From: Simon Davis
Sent: 15 March 2019 11:13
To: [REDACTED]
Subject: RE: BR/326/18/PL

The royal Hotel - BR/326/18/PL

The application is for the refurbishment of the existing building, external alterations, extensions and reconfiguration of a previously permitted conversion. The proposal is to provide an A3 restaurant and 27 flats.

TYPICAL WINDOW DETAIL

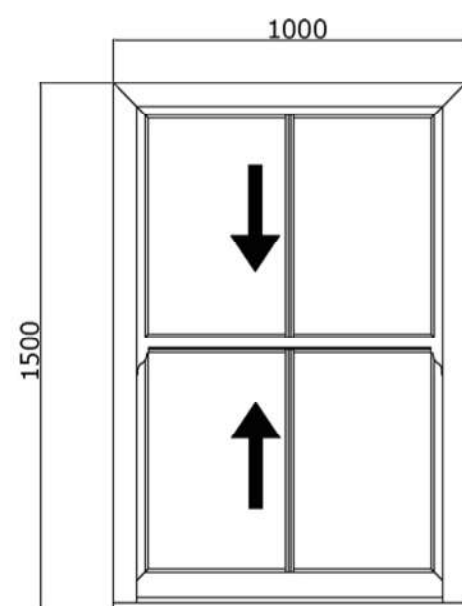
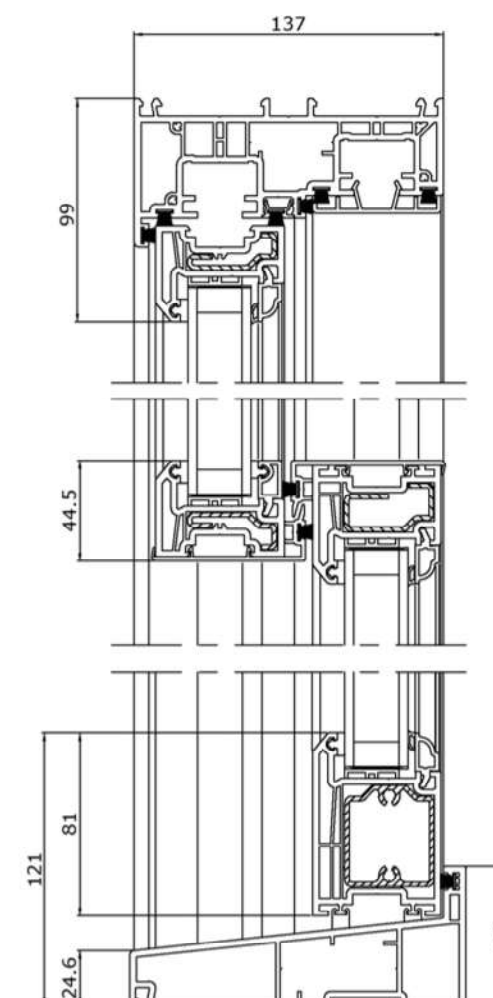
The fenestration of the building will have a significant impact upon the success of the works, and should closely reflect the remaining traditional windows. It is considered that the best approach would be to use sliding sash windows. The windows should also be such that the design/measurements closely reflect the existing, remaining traditional windows.

It is suggested that details of all of the windows, railings and external paint colours be supplied prior to works commencing in order to ensure that they reflect the traditional character of the conservation area. .
